Was secondary pad tested?

MMC helipad questions and concerns

Thank you for chatting with me last week about the upcoming sound tests for the two new Maine Medical Center helipads. As we discussed, my property at 19 Ellsworth Street is in close proximity to both of the new helipads, and has even been noted by the hospital as one that might qualify for sound mitigation assistance.

*Appendix 5: East Tower Helipad Design*

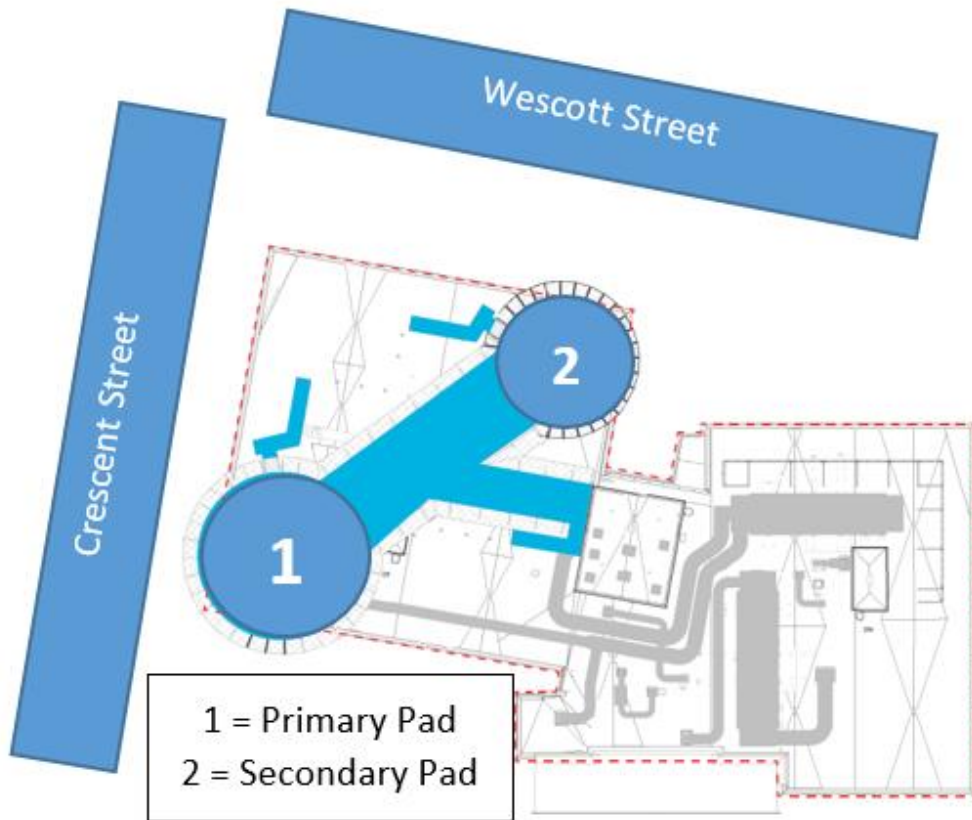
Sara again from 19 Ellsworth Street. I just read through a draft of the MMC helipad Sound Measurement Plan and related consultant correspondence that Alvah shared with me and an important question arises -- has the secondary helipad that hangs over our neighborhood been tested at all? Are there any plans to test it?

- Will the study include the secondary helipad and, if not, can it be added? The secondary's effects on my property and others around me looks to be significant because of its position on the East Tower. Part of the pad is reaching over the side and is almost literally above my house, with no hospital structure muffling that sound.

*Appendix 6: 2017 Sound Study Measurement Locations*

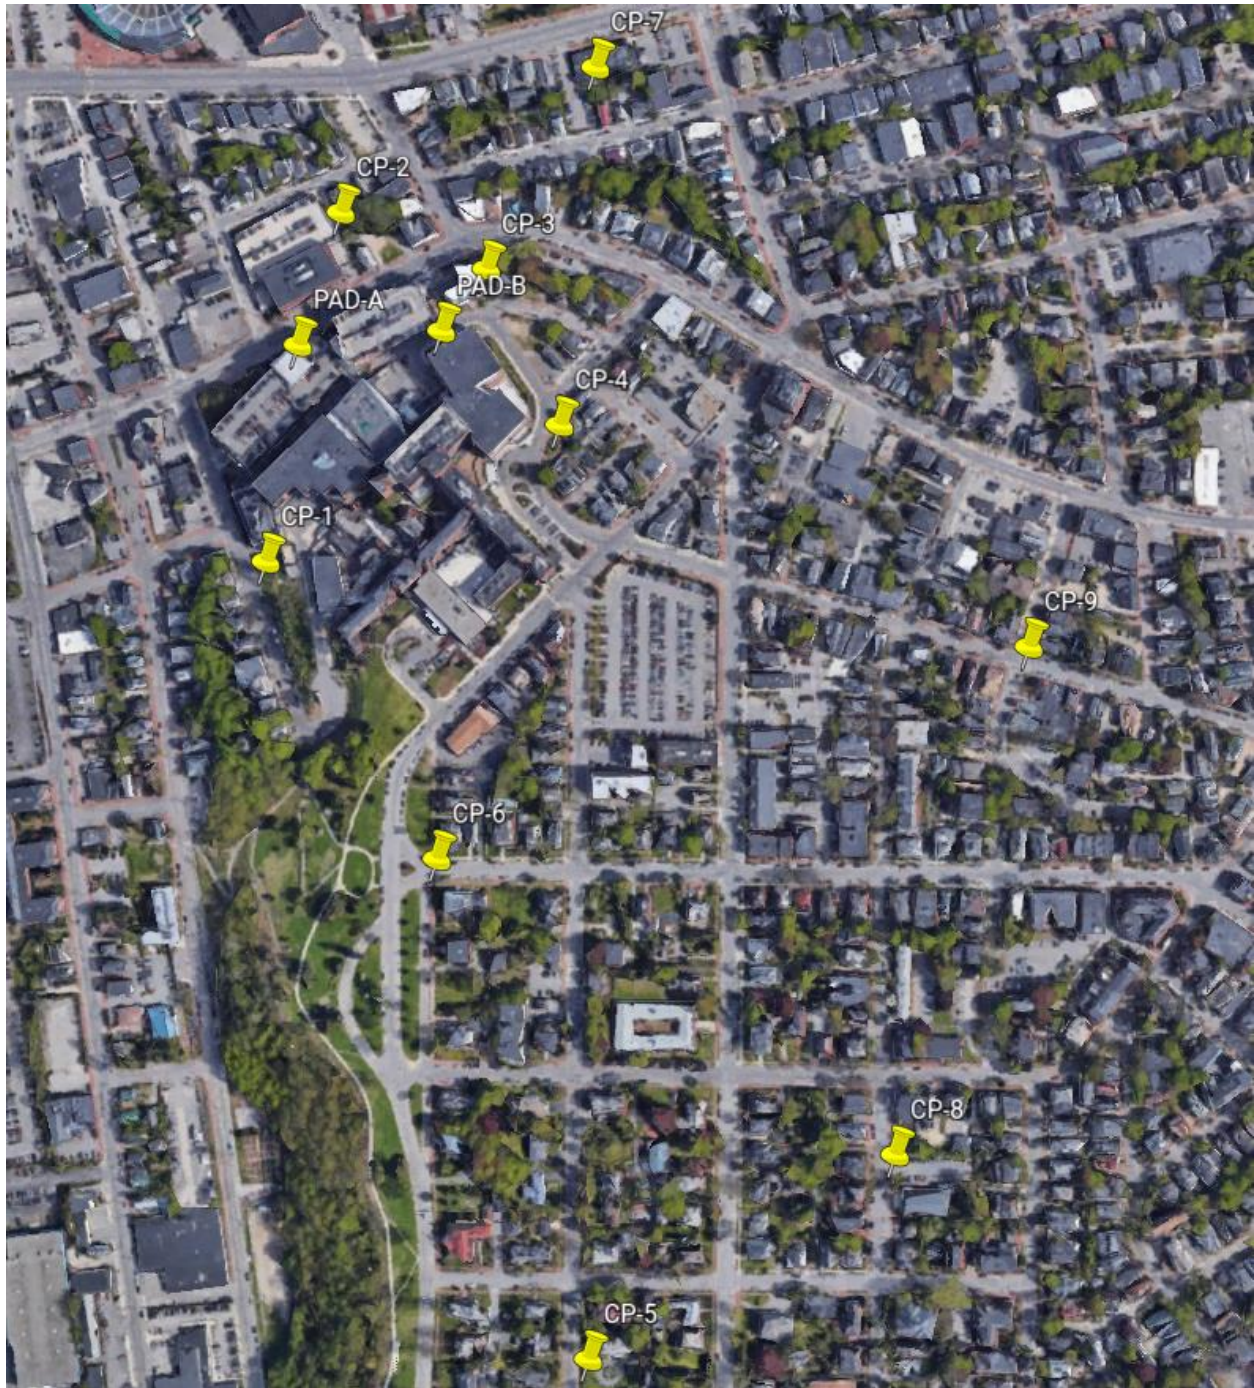
According to a map from Russell Acoustics attached to a letter dated August 6, 2017, two helipads were tested with sample flights. One is located away from the street on the East Tower (Pad B on the map which, I believe, will be the primary pad) and the other (Pad A), strangely, was the helipad atop the current parking garage that will soon be defunct. Why wasn't what will be the secondary pad also tested for sound? This is the pad that sticks out over the edge of the East Tower, hovers over our properties in Bramhall, and lacks structures around it to mitigate sound.

If I'm reading this all correctly, the dBA of helicopter noise according to the study on pads A and B is in the red zone -- above 90 in some cases. And this only covers the pads set back from the street. I can only imagine that the secondary pad, jutting out as it does, would have a dBA significantly higher. Can you tell me whether there are plans to test that secondary pad? And if that study has been done, can I see the results? I have CC'd Alvah, Liz, and my councilor Spencer Thibideau on this email.
